OAKDALE SOUTH ESTATE - SSDA 6917

SECTION 96(1A) MODIFICATION
APPLICATION - MOD 4

A draft Section 96(1A) Modification Report was submitted to the DP&E on 23 May 2017. The Department comments are detailed in the following table along with a reference to where these matters are addressed in the Modification Report.

Estate Road 01

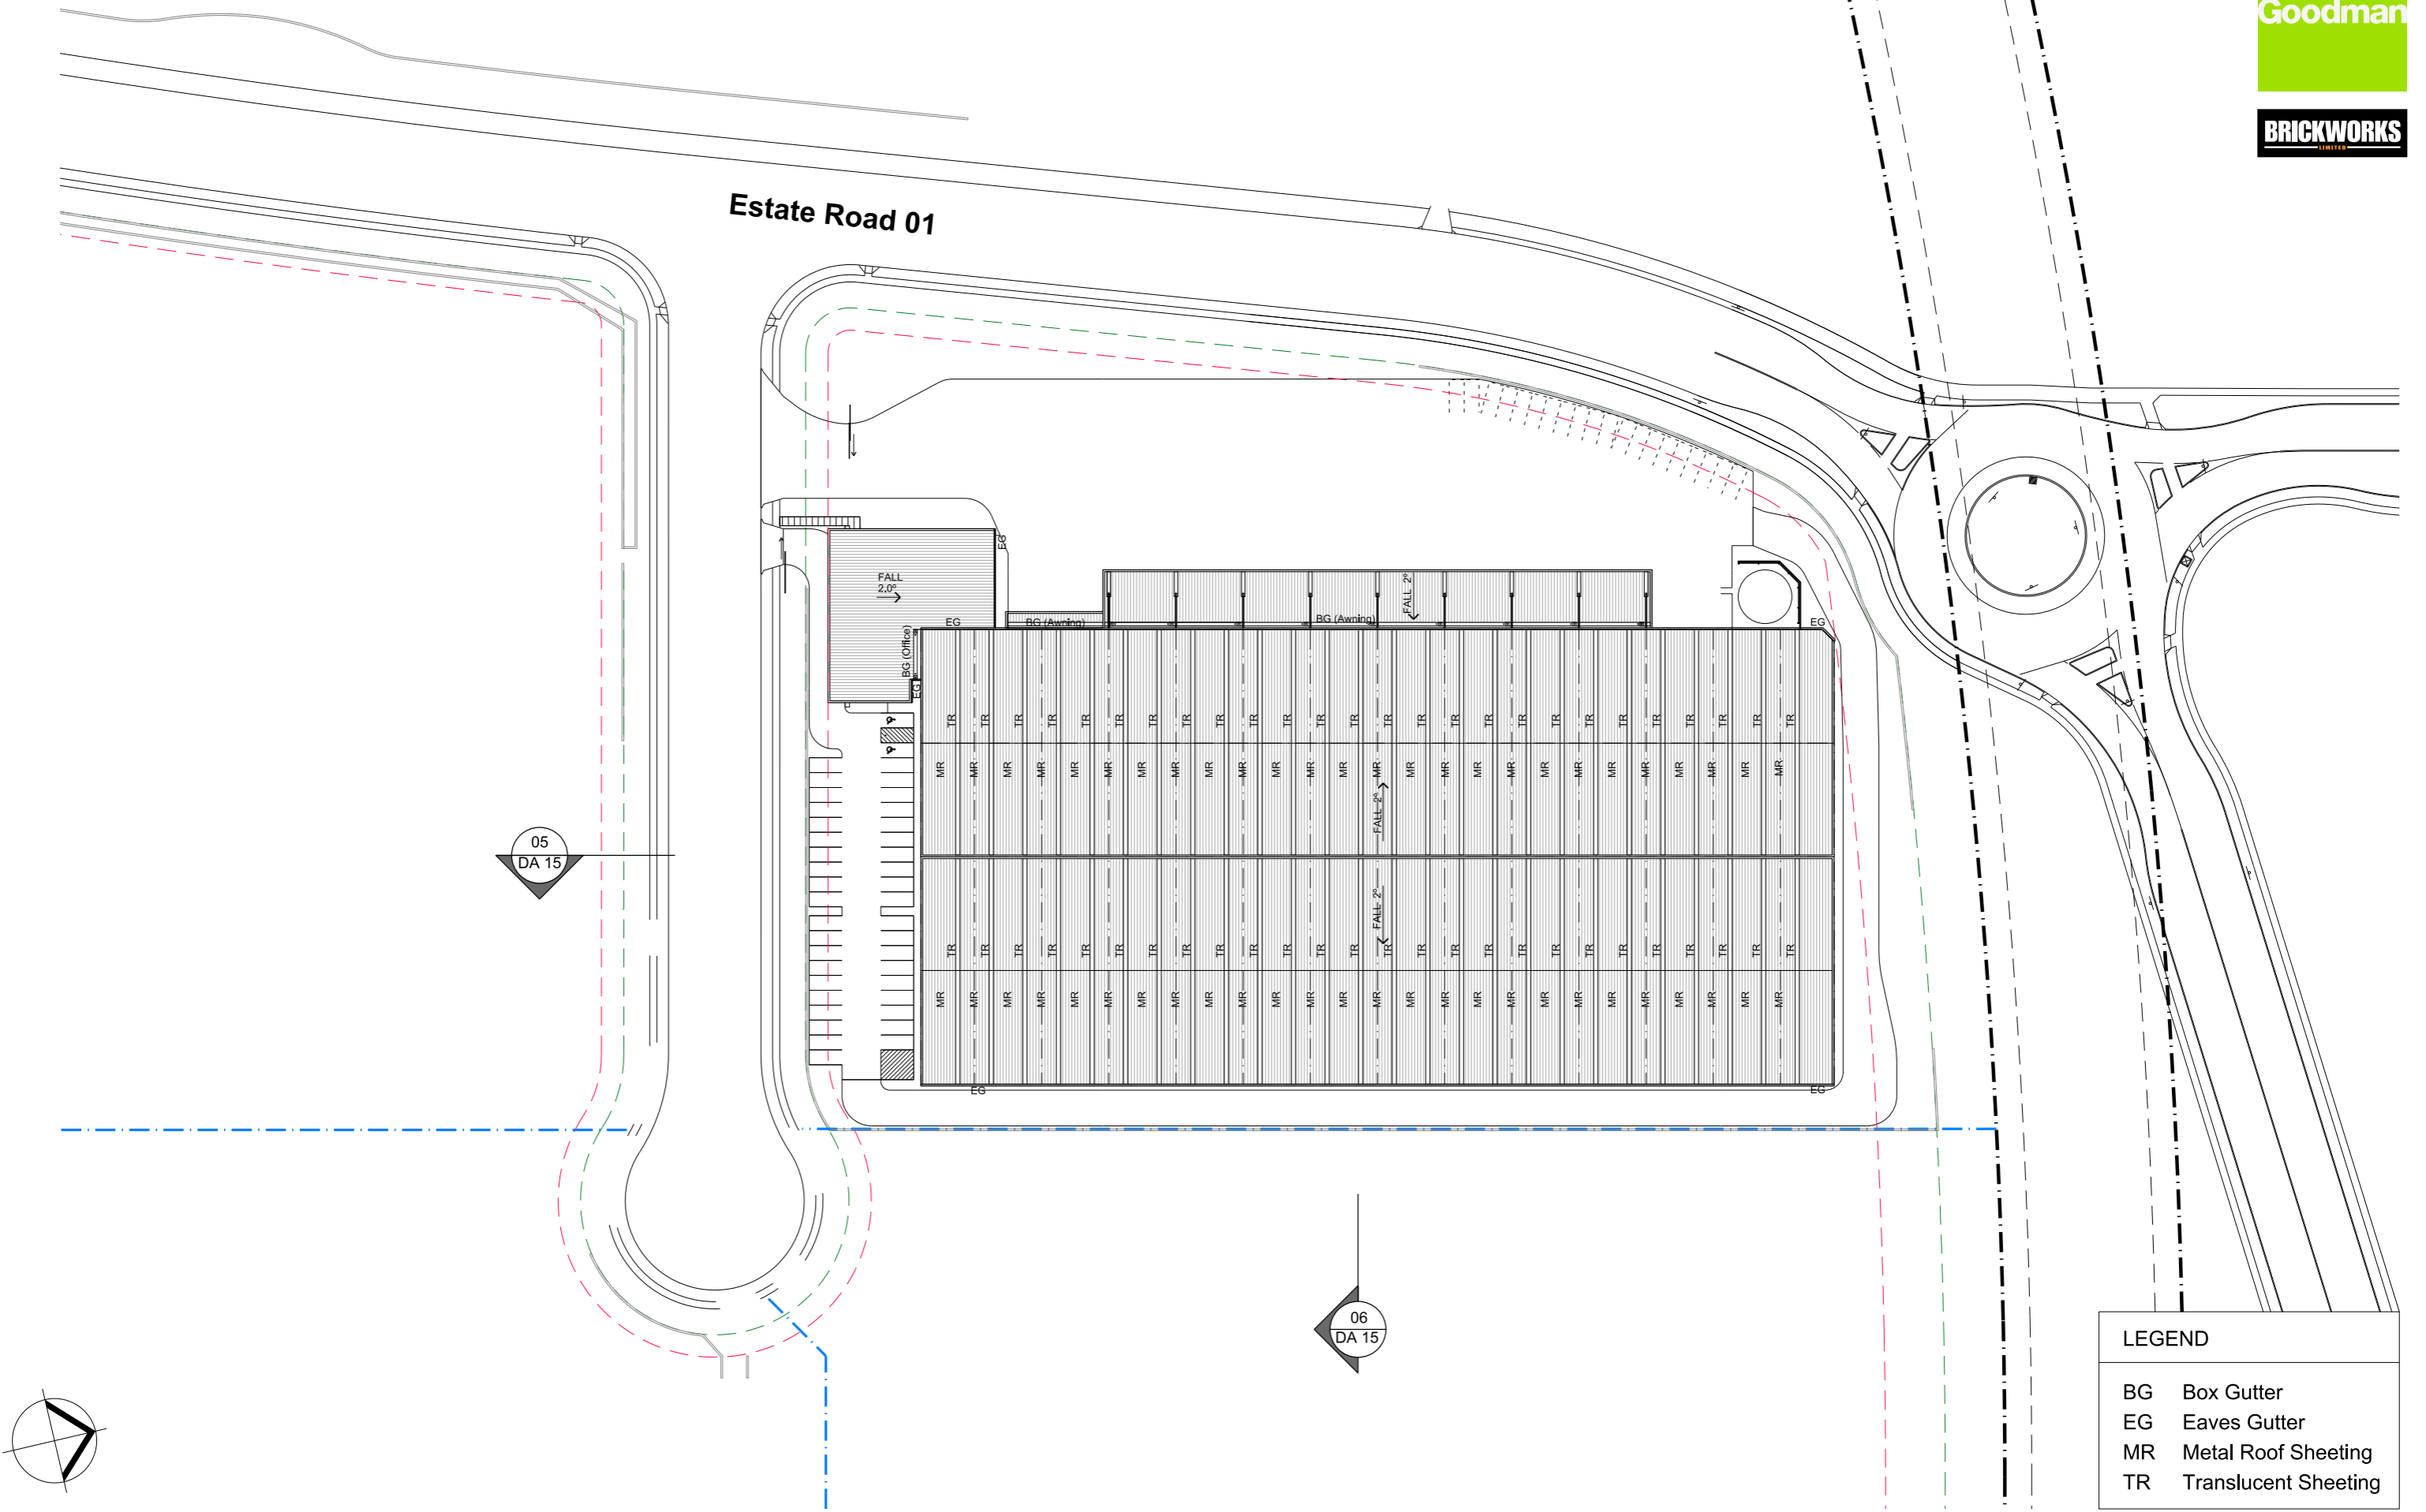
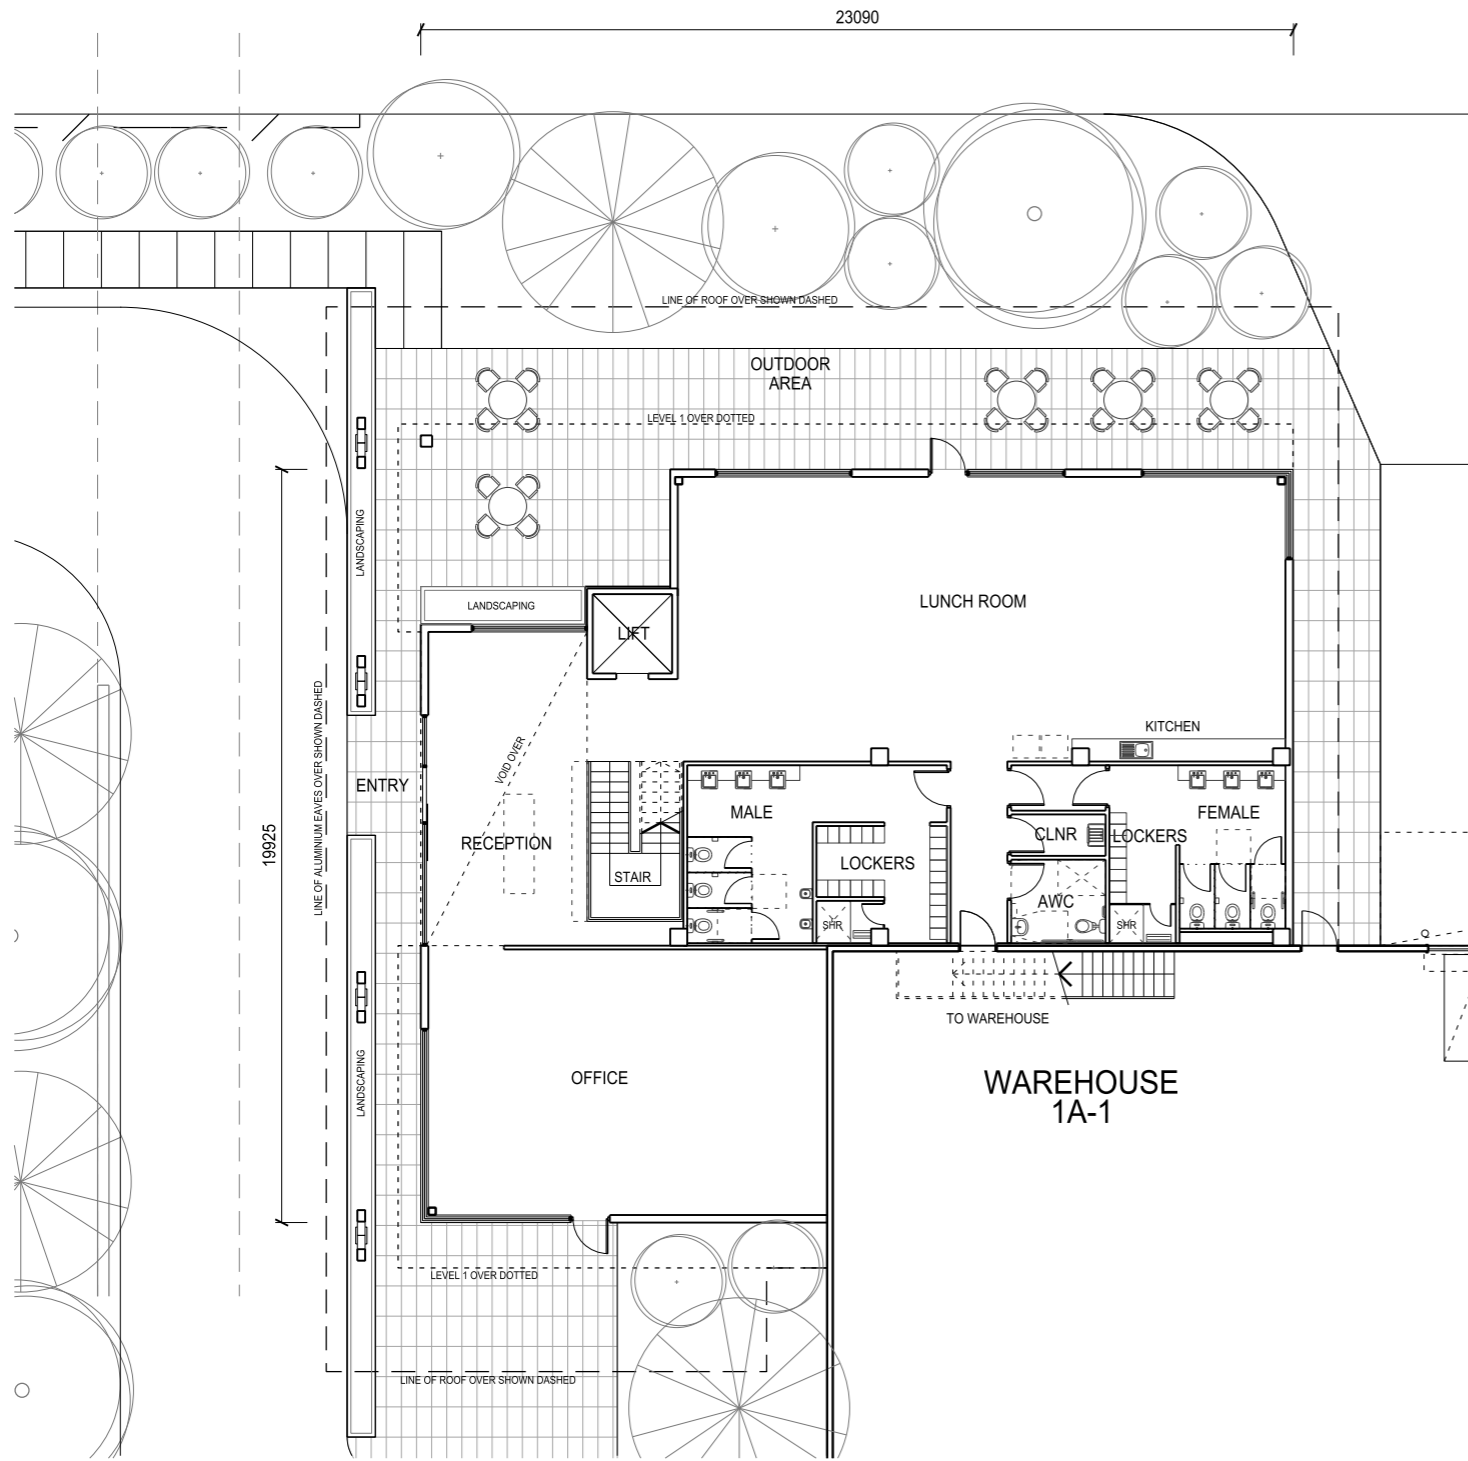
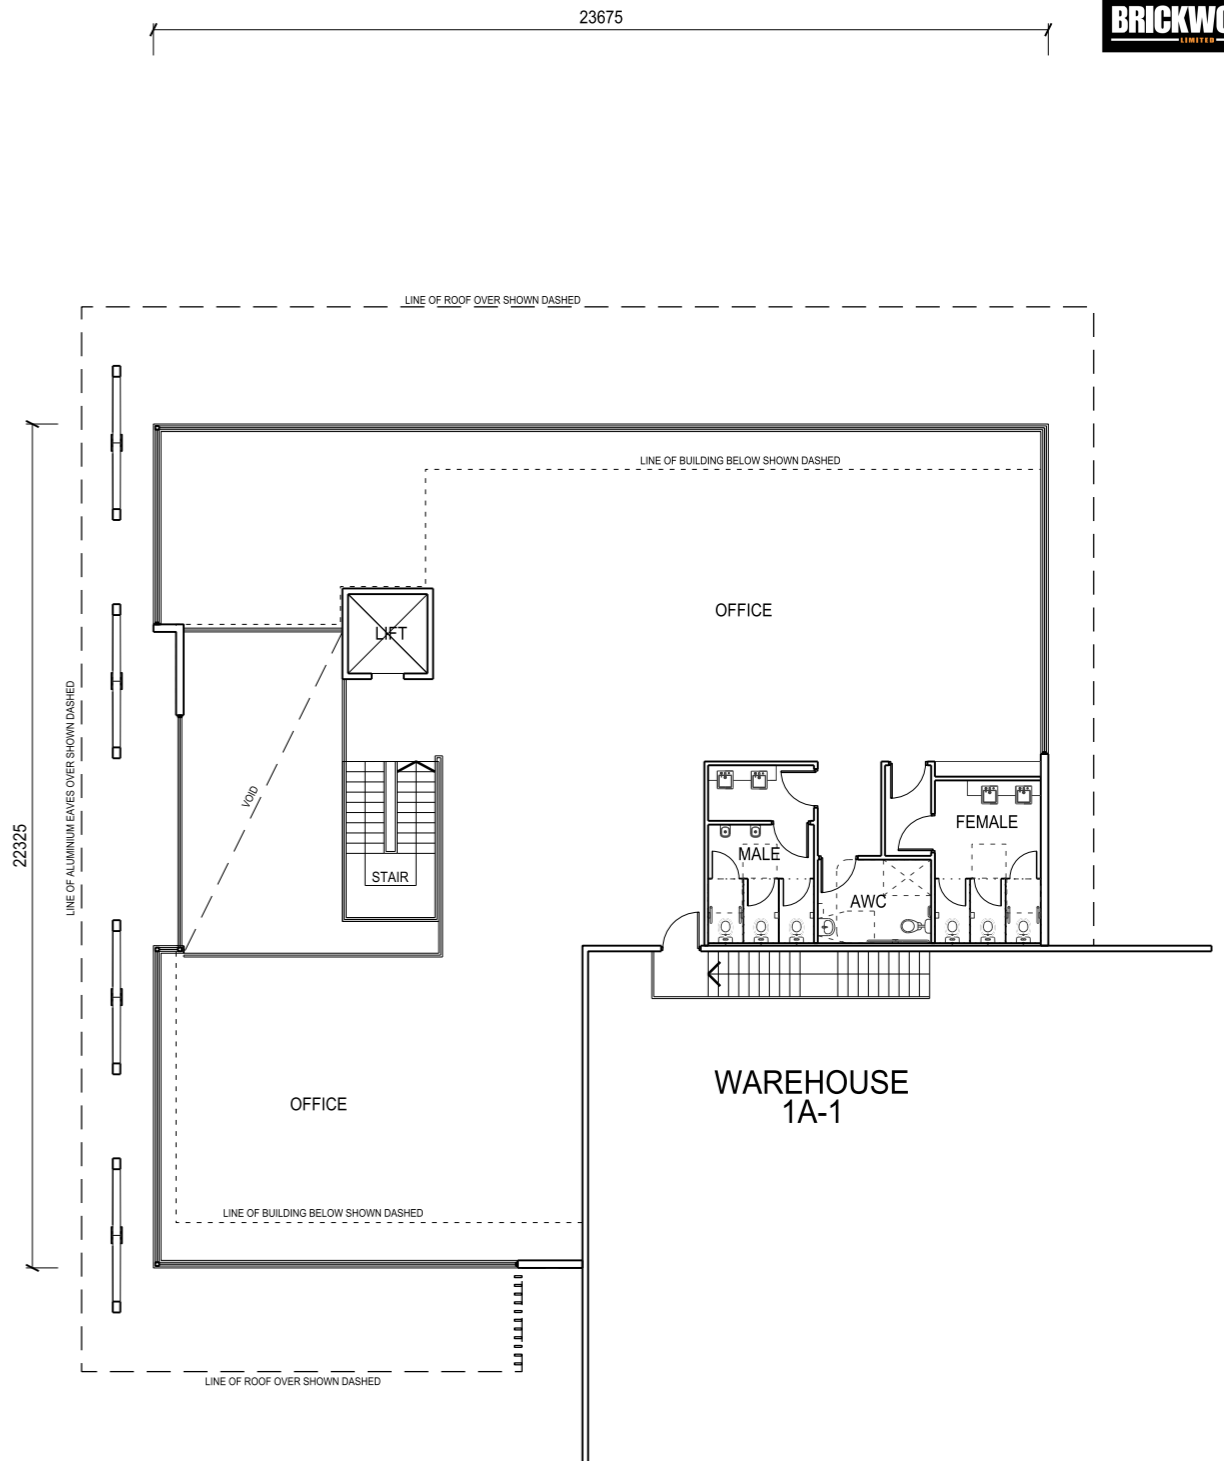
Item/ Description	Document Reference/Comment
	layout with both the setback and landscape screening to Estate Road 01 is considered a preferable urban design outcome. Addressed in Section 5.2.4.
The proposed location of the water tanks/pump room adjacent to Unit 1A has a poor presentation to Estate Road 01 and the future proposed Southern Link Road. This should be reconsidered.	Refer revised architectural plans which now incorporate a screening element to the tanks / pump room. Addressed in Section 5.2.4 and Architectural Plans at Appendix A.
Provide proposed signage details and specifications.	Estate signage details and specifications are provided on plan MP 11(K), which details sign dimensions, design and location. Building façade signage design has only been included for Building 1B (Iron Mountain) and is yet to be finalised for the other buildings. We suggest that details of façade signage may be provided to DoP for approval once occupier signage is confirmed, as permitted by Condition E68. The signage for Site 1B, Iron Mountain, is included on the elevation drawings for this building (the dimensions of these façade signs are also included). Addressed in Section 5.2.4 and Architectural Plans at Appendix A.
